Please ask for: Ms Iqraa Malik
Email: iqraa.malik@terraquest.co.uk
Telephone: 01212341390
Our Ref: FG/79/21/PL
Your Ref:
Date: 28th April 2021

Application for Planning Permission

Development: Garden Outbuilding
Location: 18a Ocean Drive Ferring BN12 5GJ

BLOCK PLAN 1:500 @ A4
PROPOSED OUTBUILDING

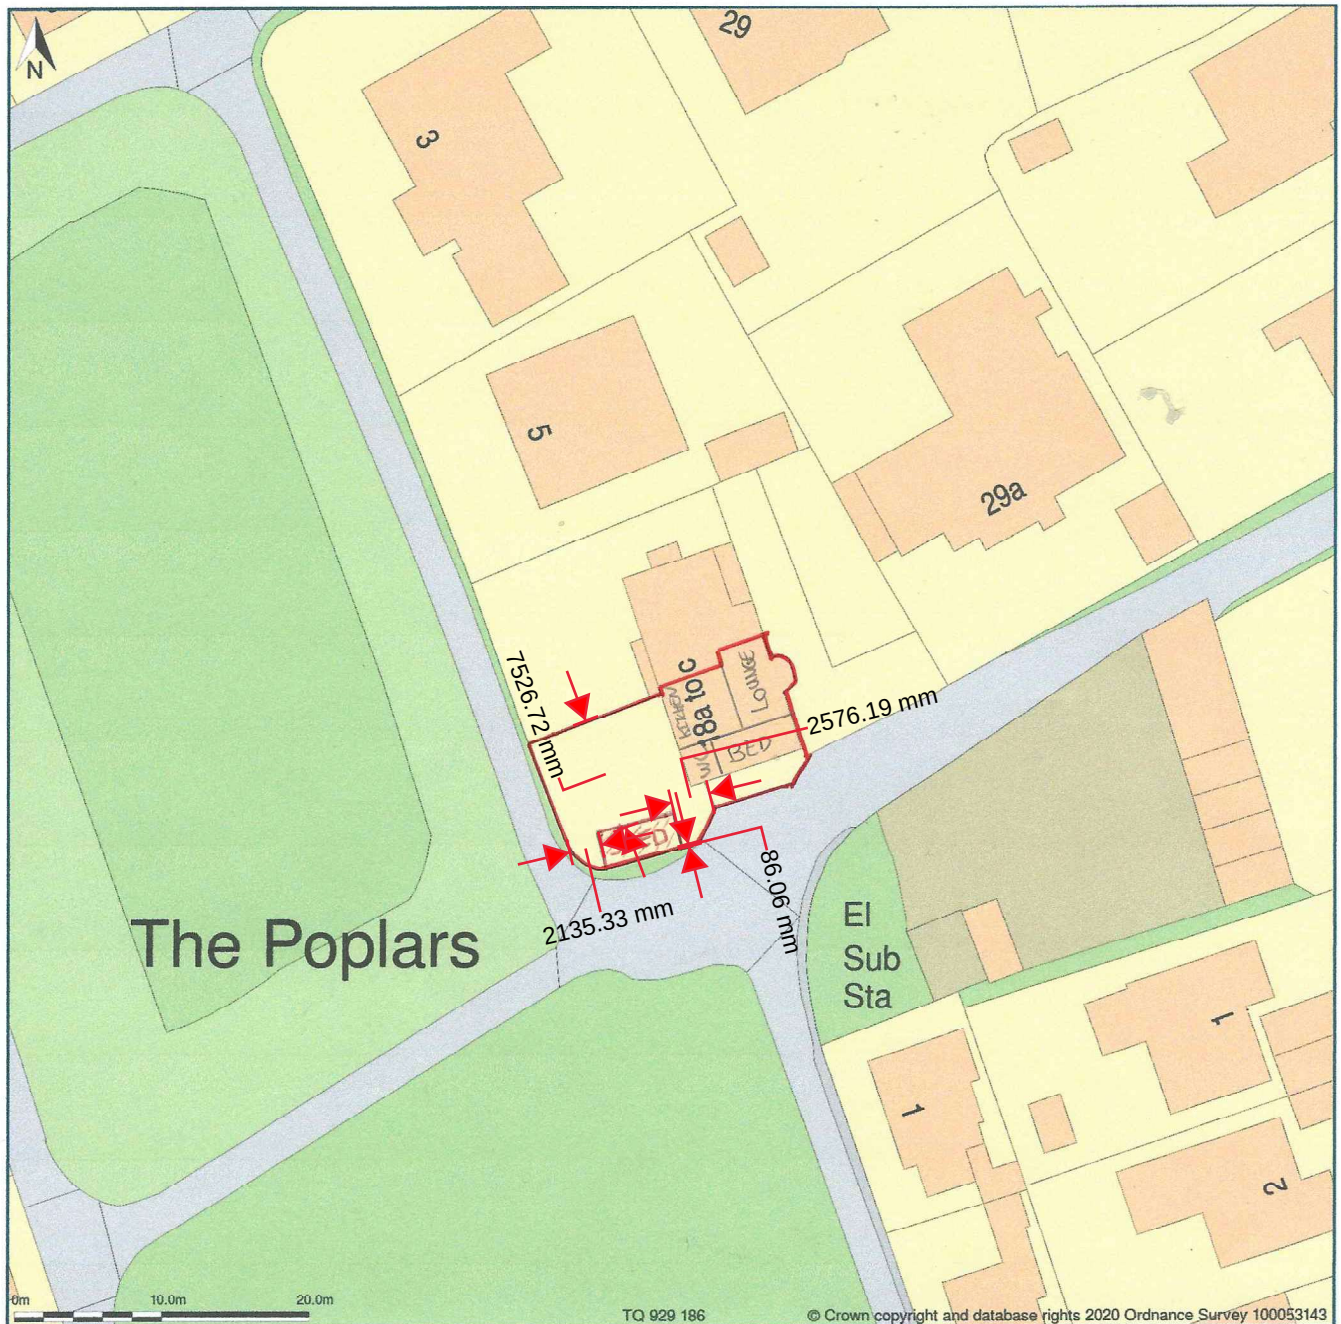
You are required to have dimensions from the proposed extension(s) to all site boundaries. Please amend.
